EPC STORMWATER REVIEW COMMENTS  
IN ORANGE BOXES WITH BLACK TEXT

### GRADING AND EROSION CONTROL PLAN JUDGE ORR ROAD RV PARK AND STORAGE EL PASO COUNTY, COLORADO

**JUDGE ORR ROAD RV PARK & STORAGE**  
**COLORADO SPRINGS, COLORADO**  
**DRAINAGE, GRADING & EROSION CONTROL COVER**

PCD PROJECT NO. PPR-16-040

**FIGURE OS-4 ORIFICE PLATE AND TRASH RACK DETAILS AND NOTES**  
NTS

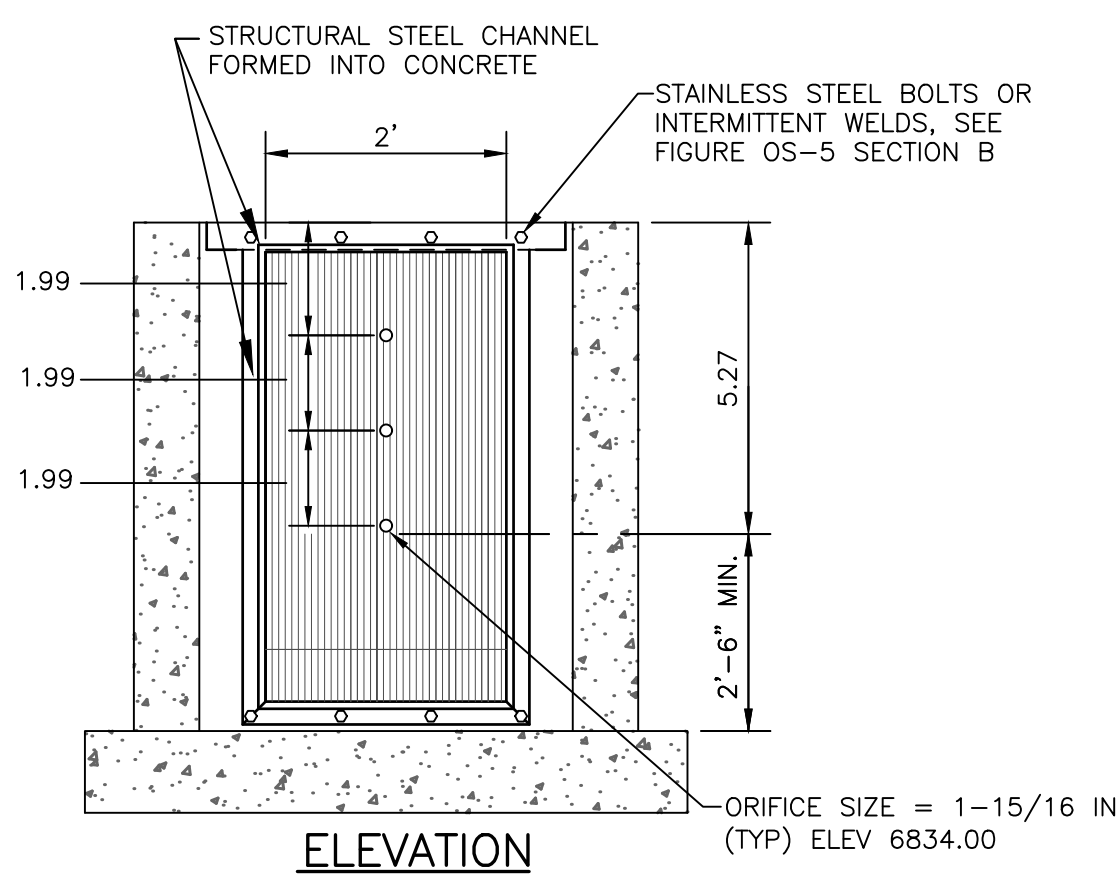
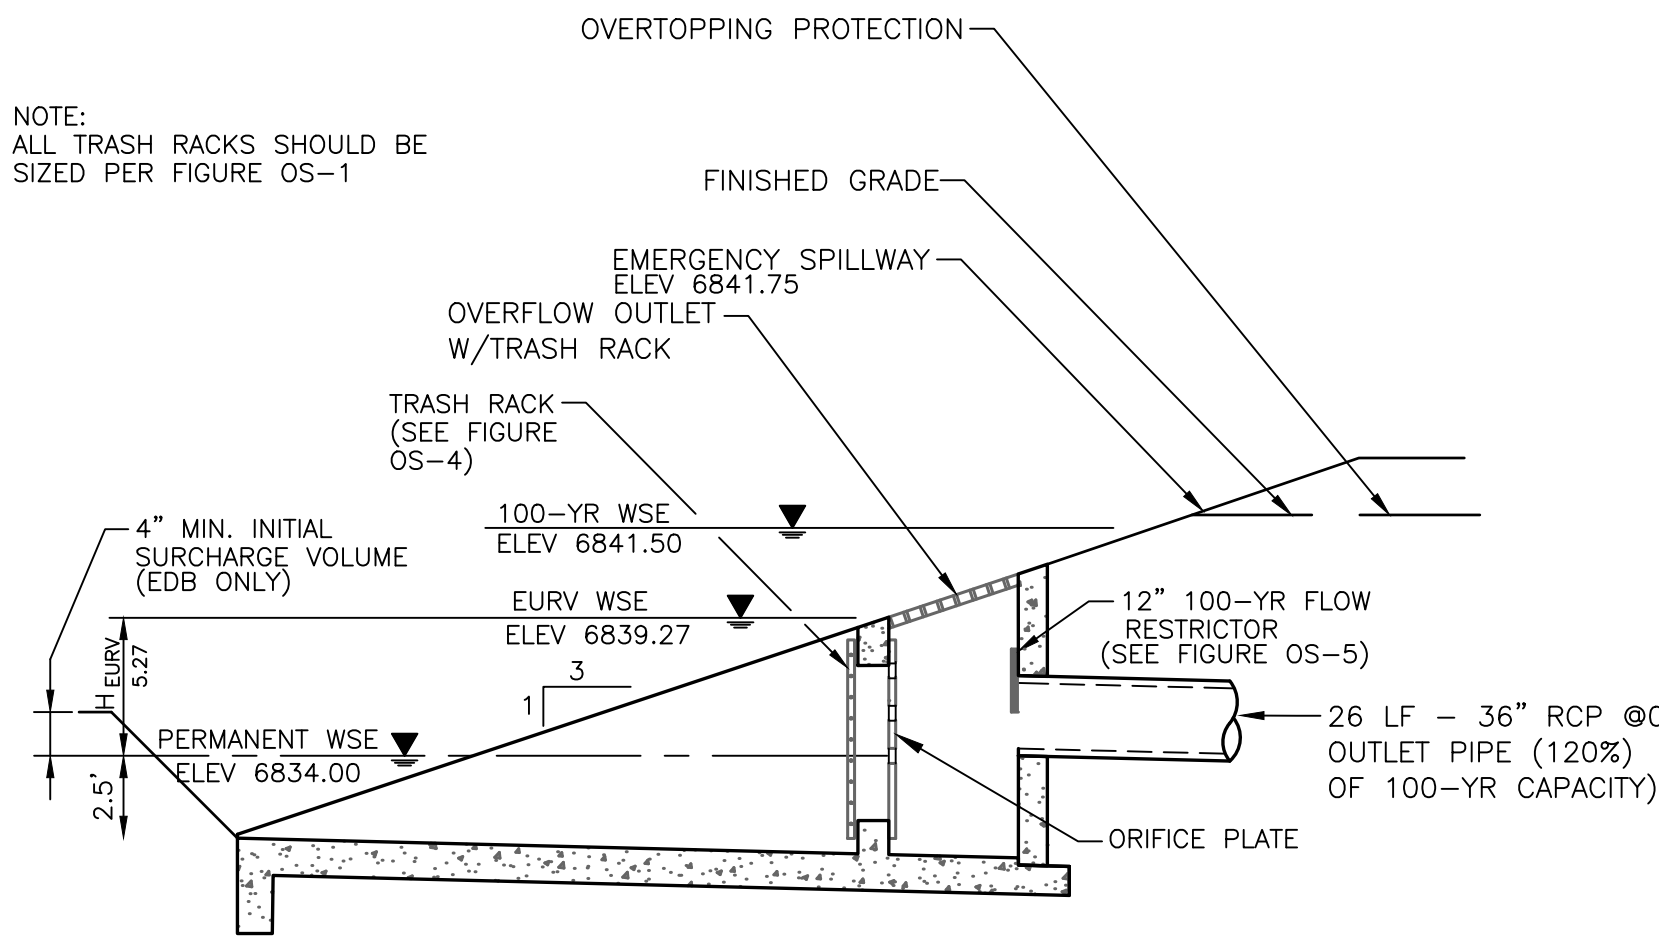
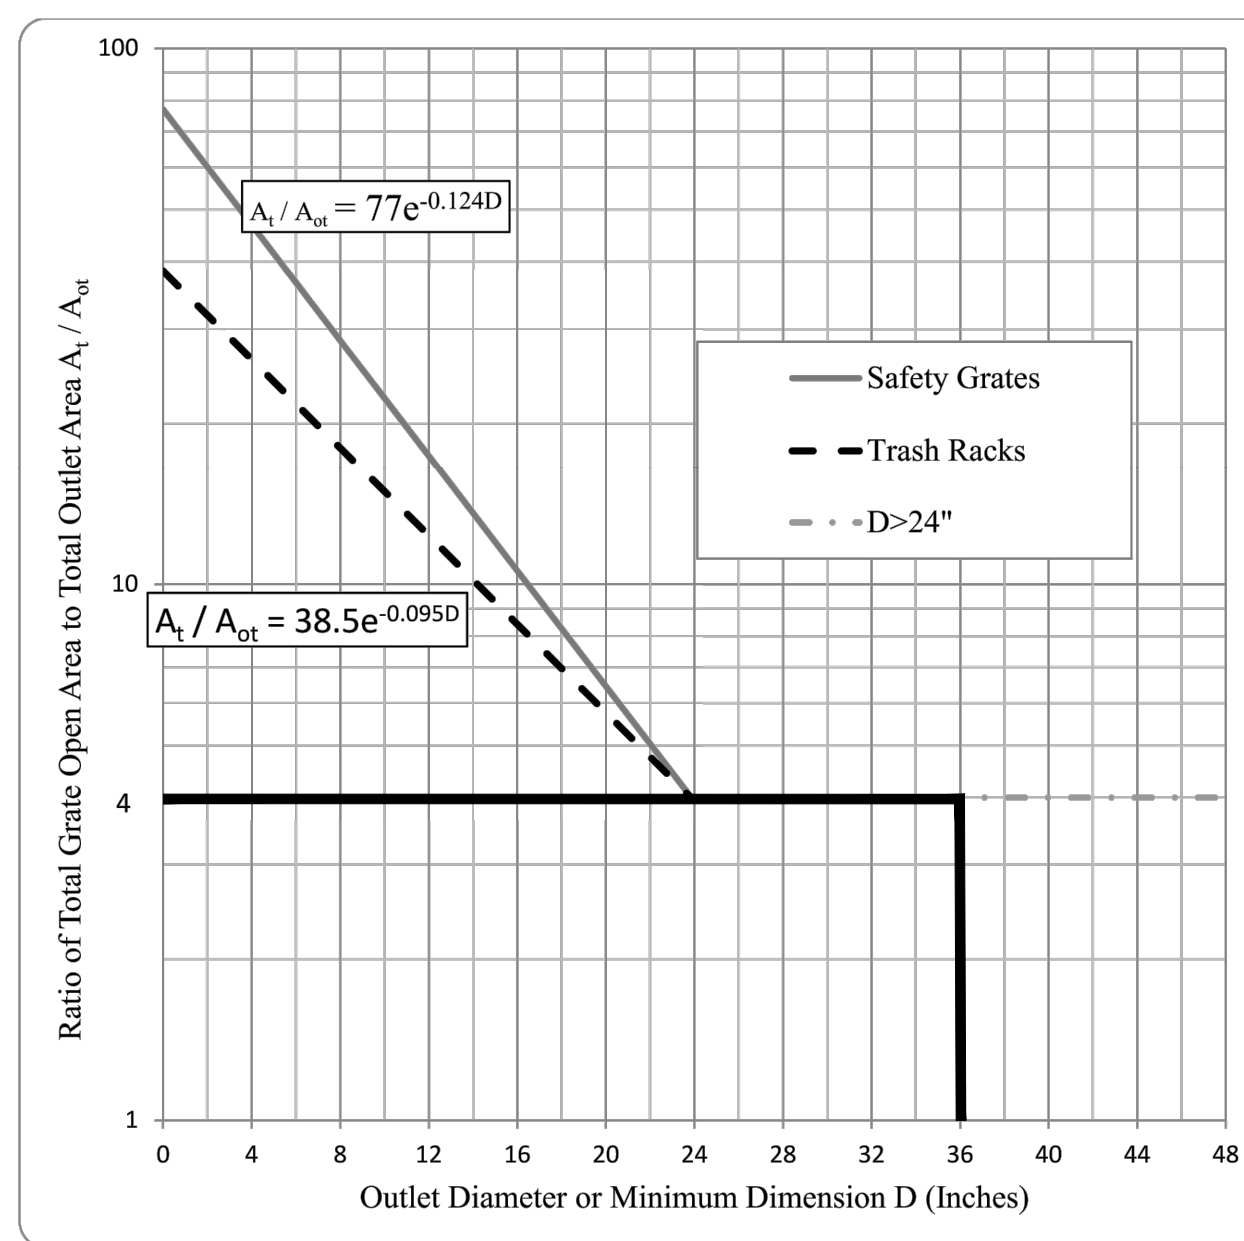
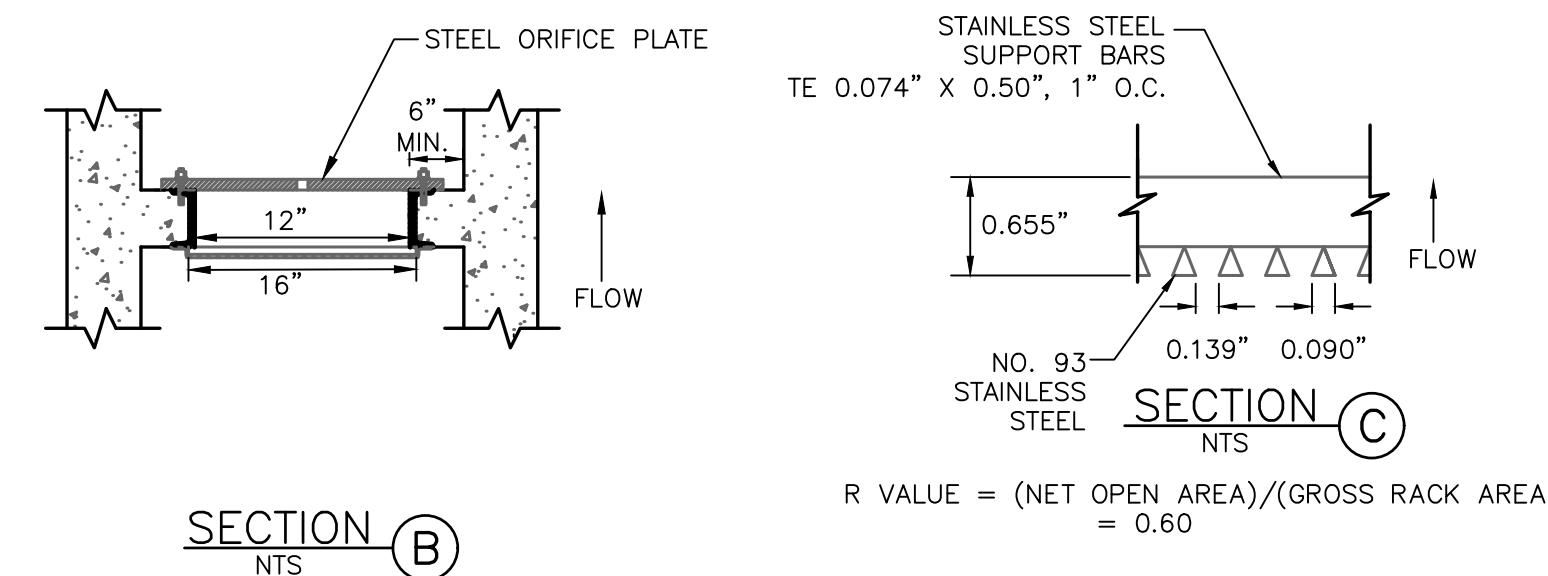
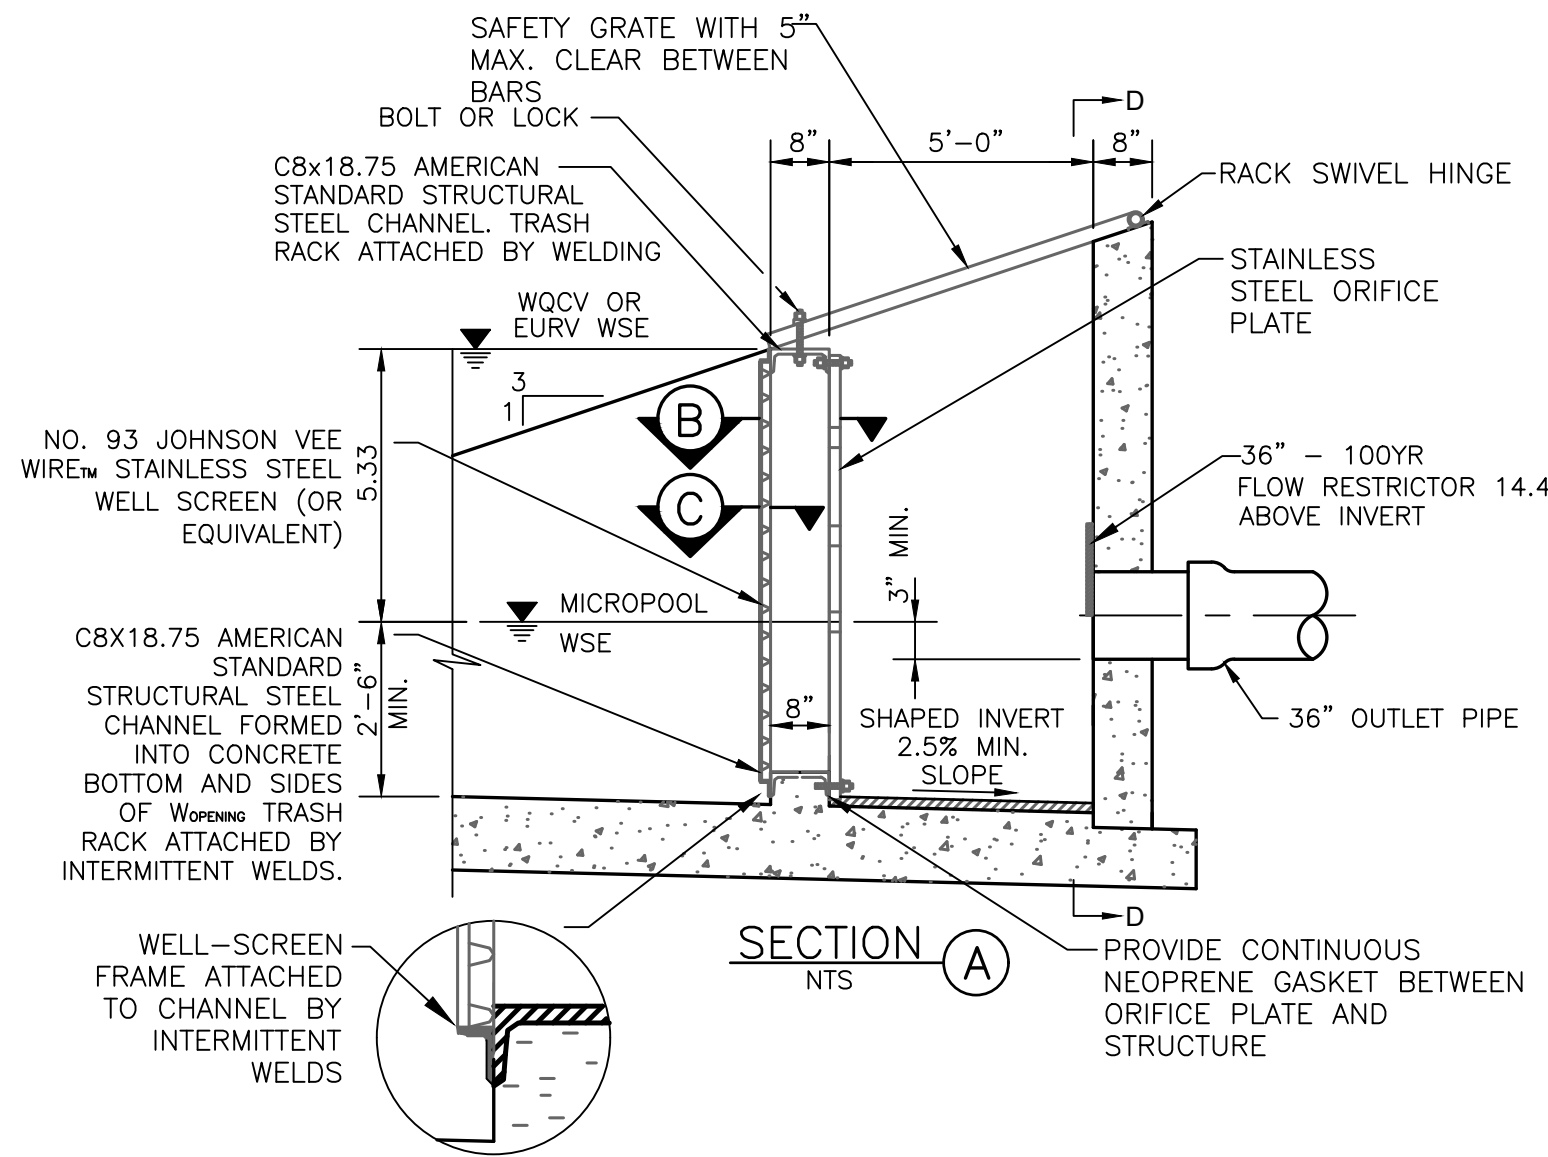
Please remove these pond details since no modifications are proposed to the pond. Acceptable just to label pond as existing.  
Or add text across the top of this sheet "details for information only" or "pond built under PPR1640, no improvements required with CDR222"
